CITY OF ALBUQUERQUE

April 11, 2022

**RE: Sandia Peak Grid BESS Facility
Conceptual Grading and Drainage Plan
Engineer's Stamp Date: 03/07/21
Hydrology File: D16D002A9**

ABLE GRID	JOB NUMBER	REV
SANDIA GRID PROJECT	172221	B
PRELIMINARY GRADING AND DRAINAGE PLAN	DRAWING NUMBER	C3-1

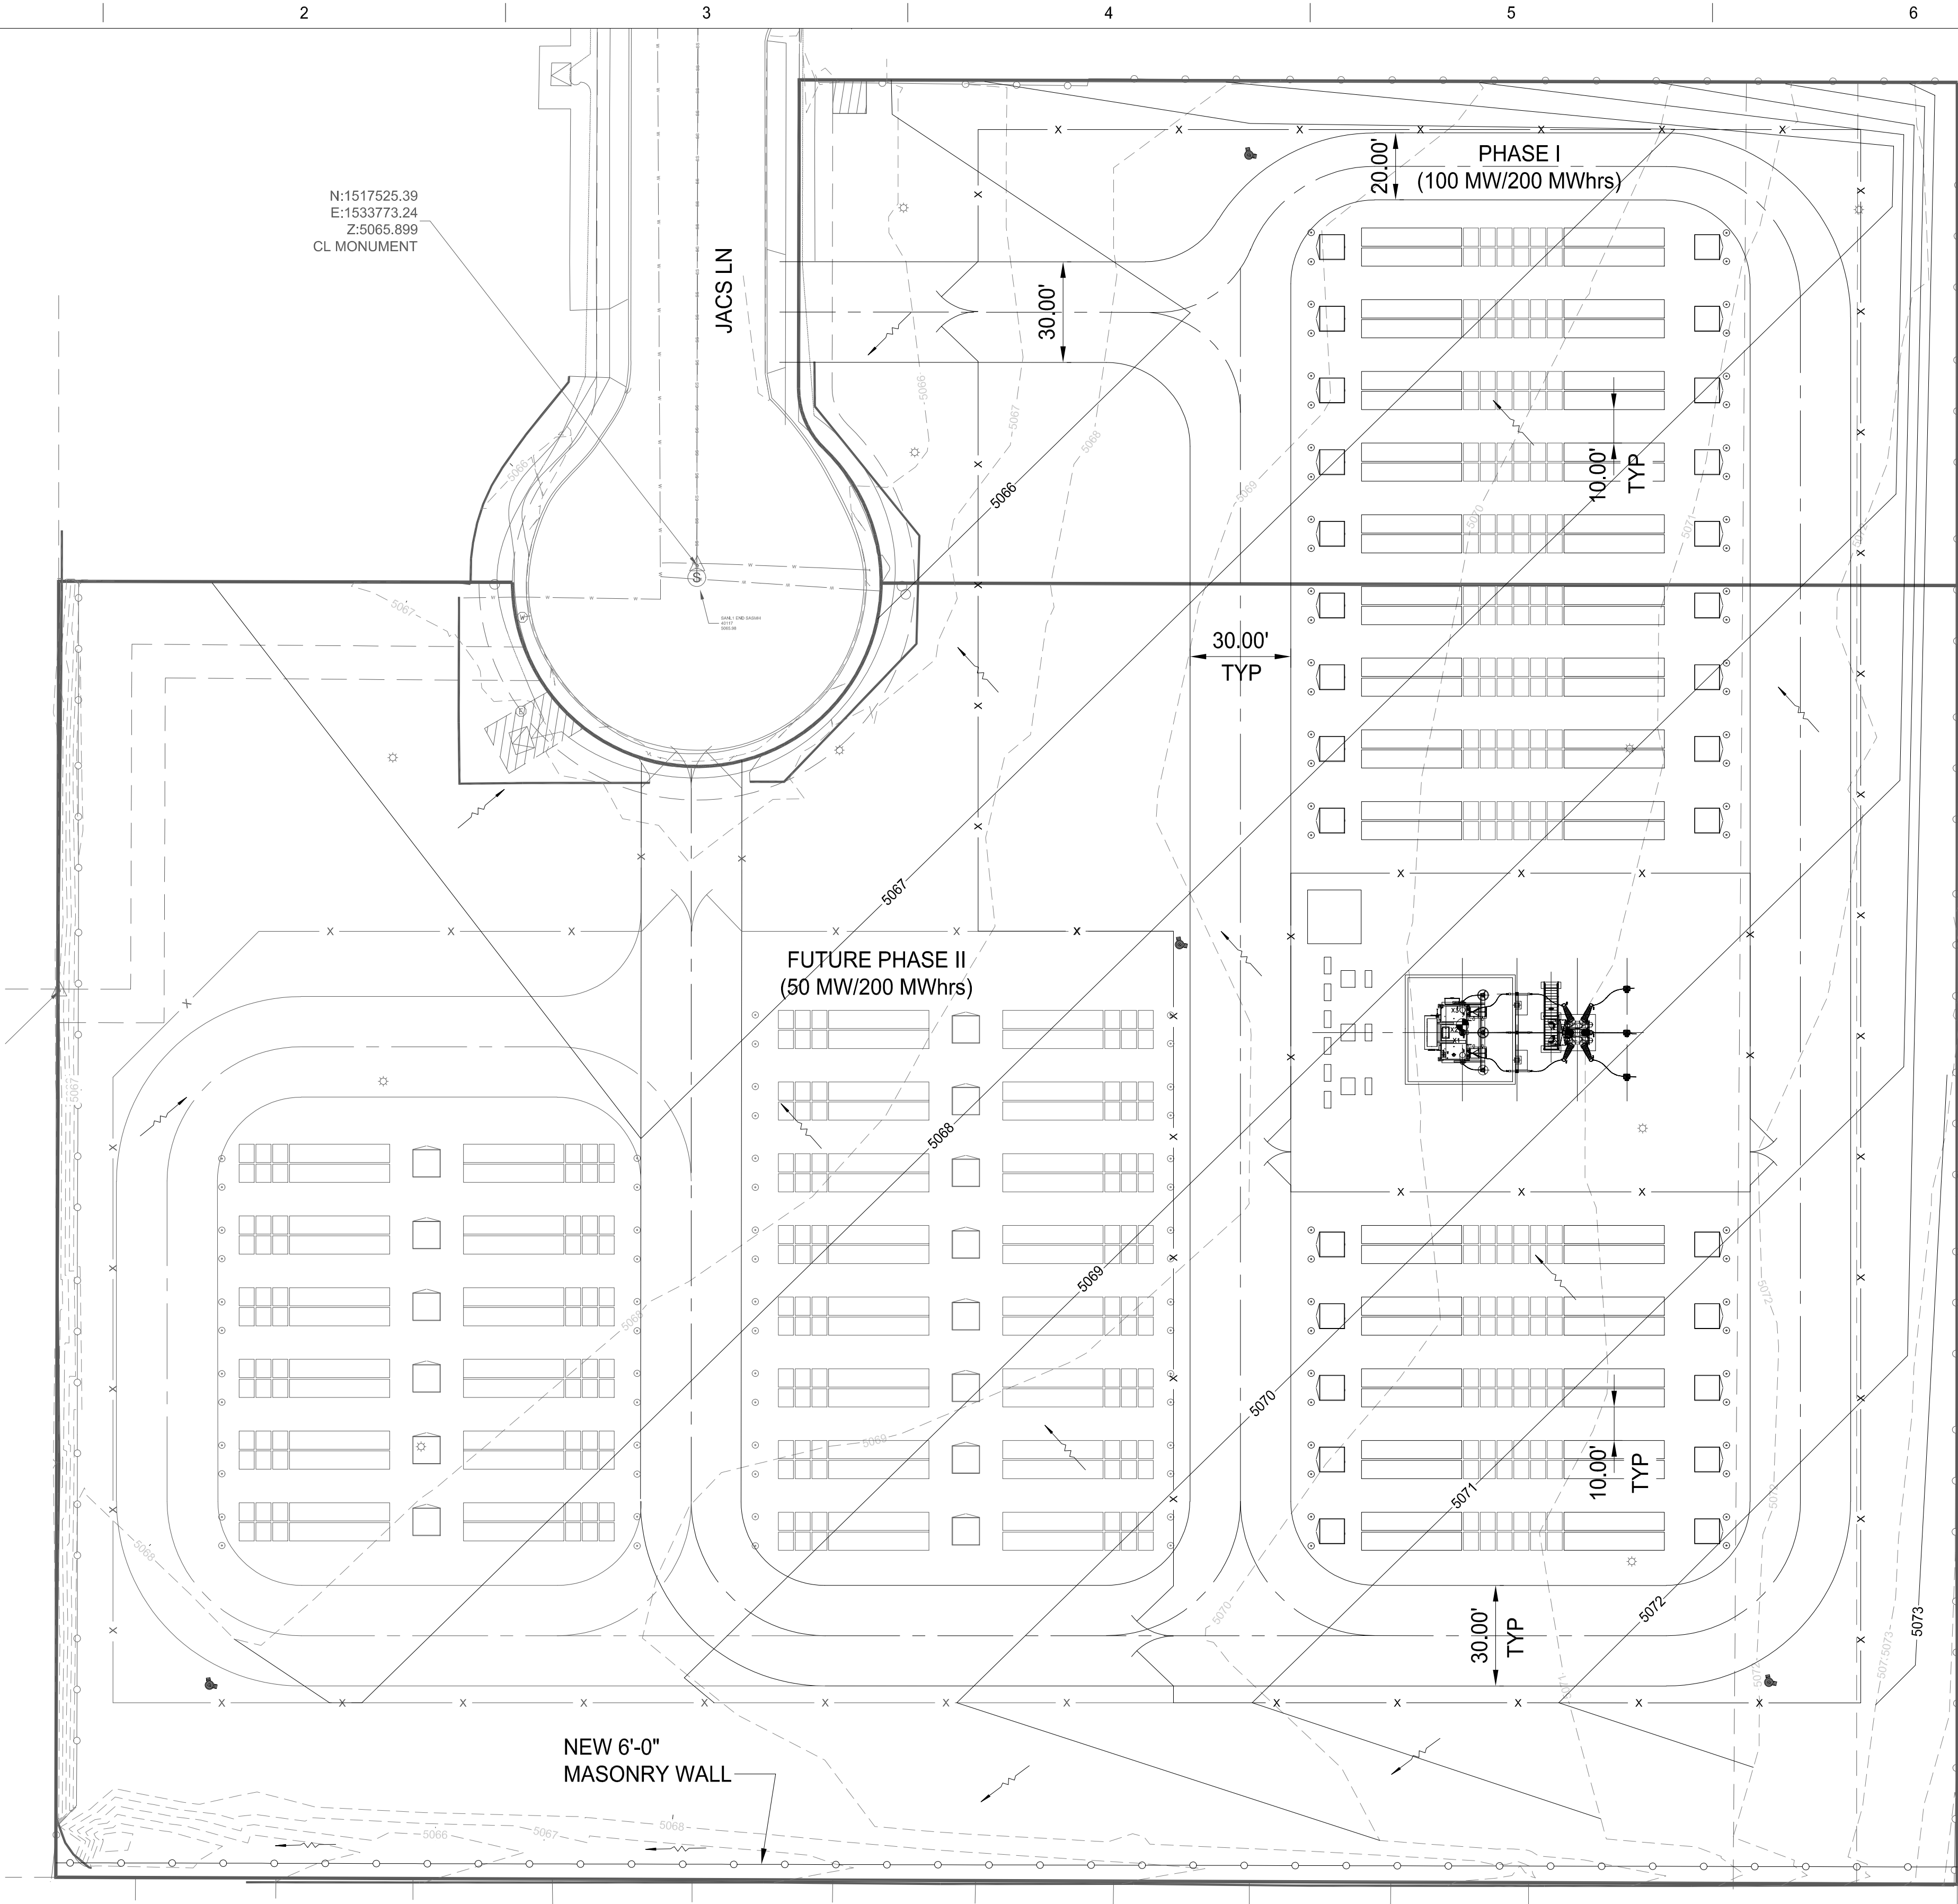
1. Please show the full calculations with references on the Grading & Drainage Plan. (not just the answers). I have attached an example for your use.
